**From:** App [REDACTED]  
**Sent:** 13 January 2022 11:13  
**To:** Sian Eggington  
**Subject:** FW: FW: FW: Request for further information LU/403/21/HH  
**Attachments:** We sent you safe versions of your files; 16 Harebell Close BN17 6WE Loft Only\_v2\_ALL.pdf

**From:** Sian Eggington <[Sian.Eggington@TerraQuest.co.uk](mailto:Sian.Eggington@TerraQuest.co.uk)>  
**Sent:** 11 January 2022 11:54  
**To:** App [REDACTED]  
**Subject:** FW: FW: Request for further information LU/403/21/HH

Site Plan

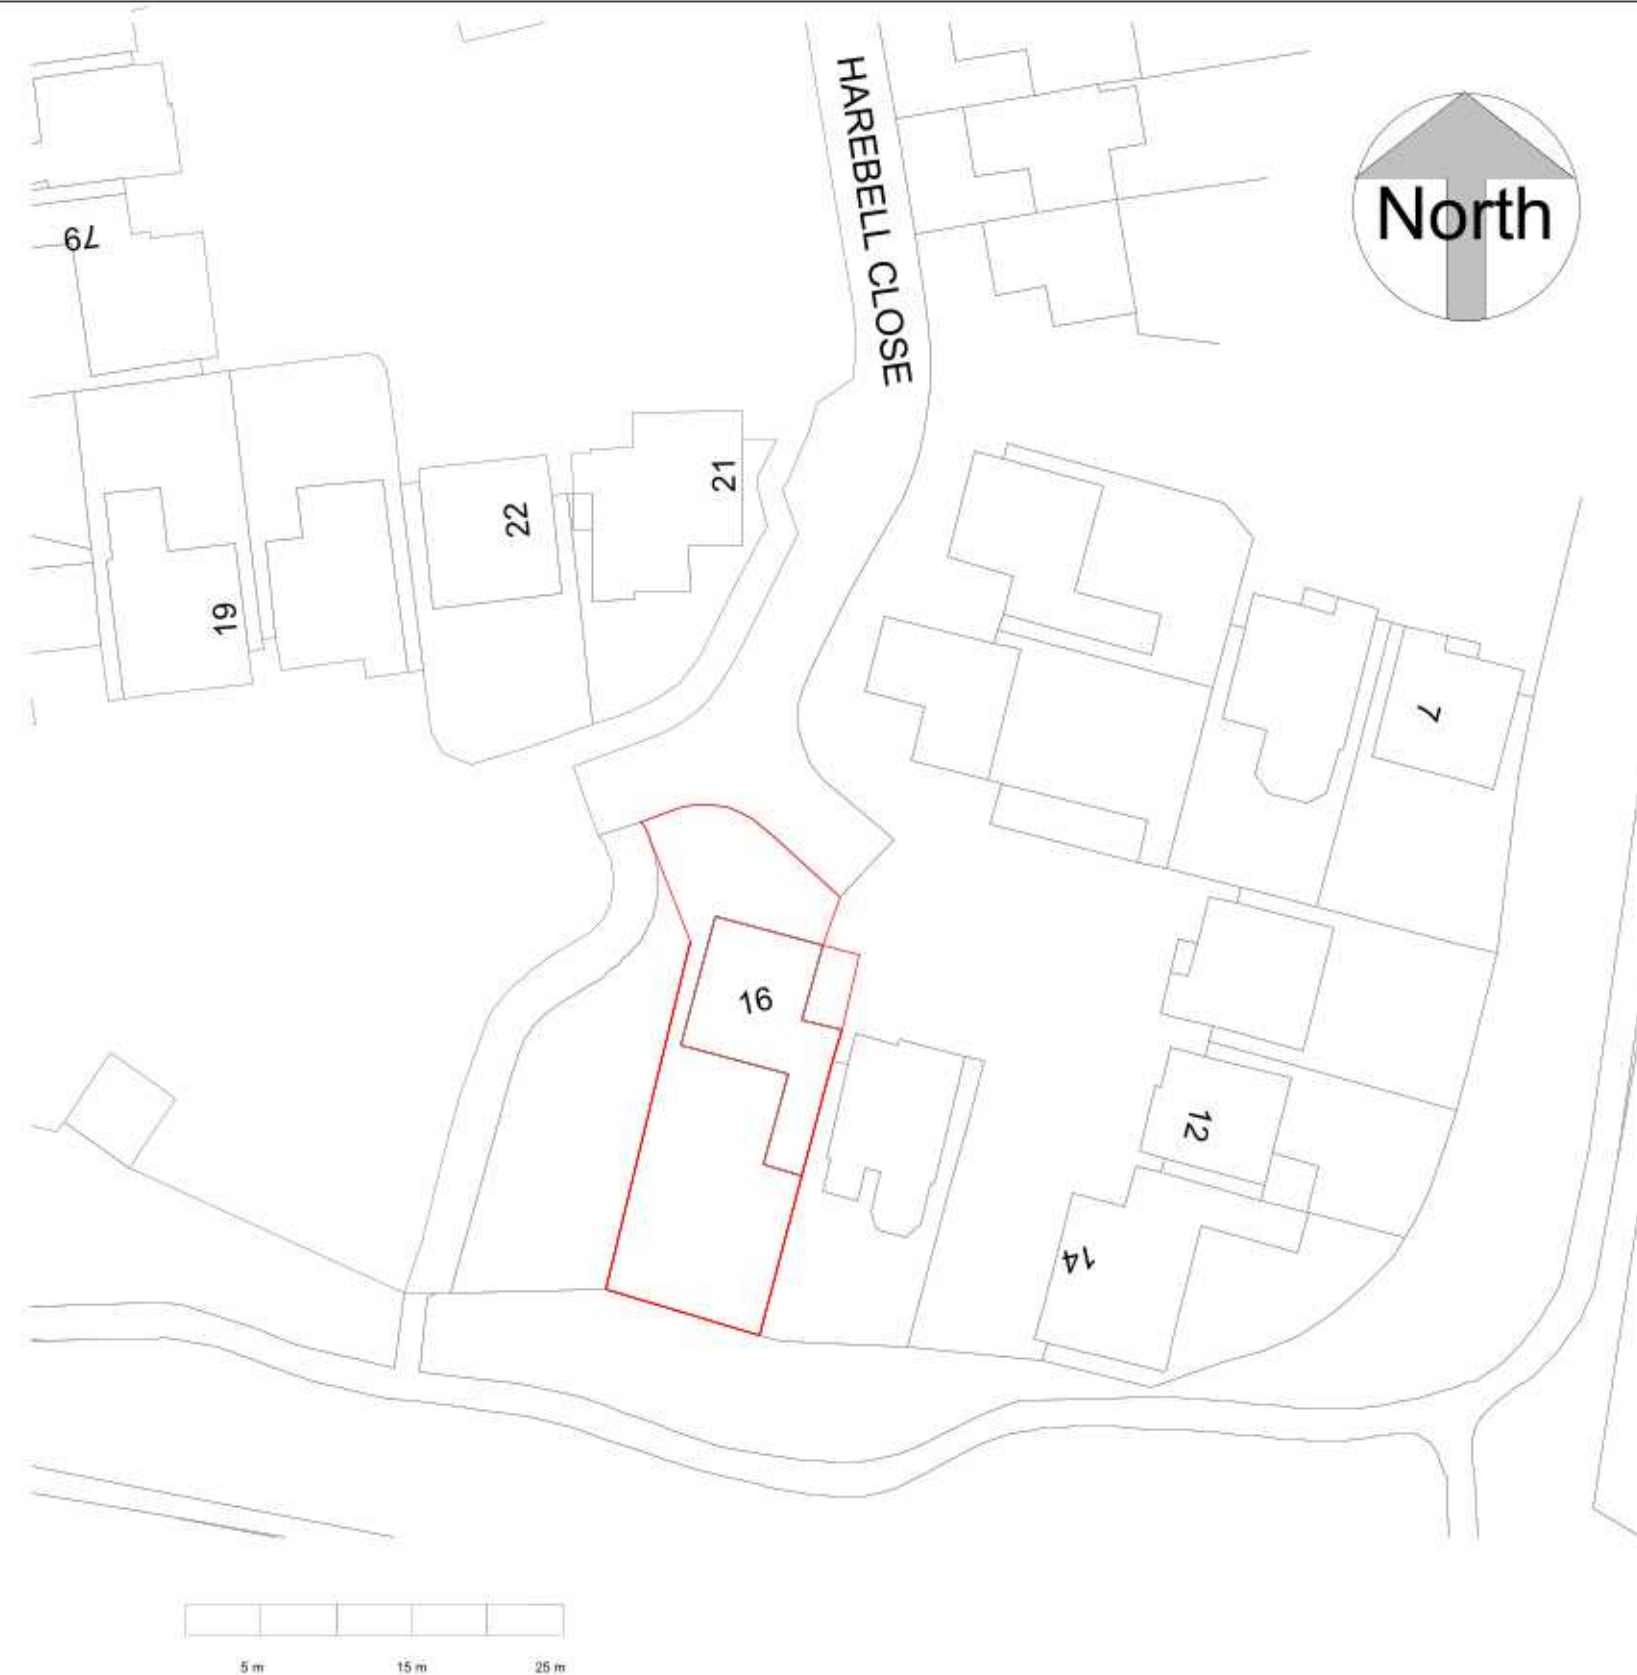
Thank you for your email, however the red outline is still incorrect the entire site including the front garden needs to be included within the red outline. If the applicant does not own the front garden then access to the road needs to be included in the red outline.
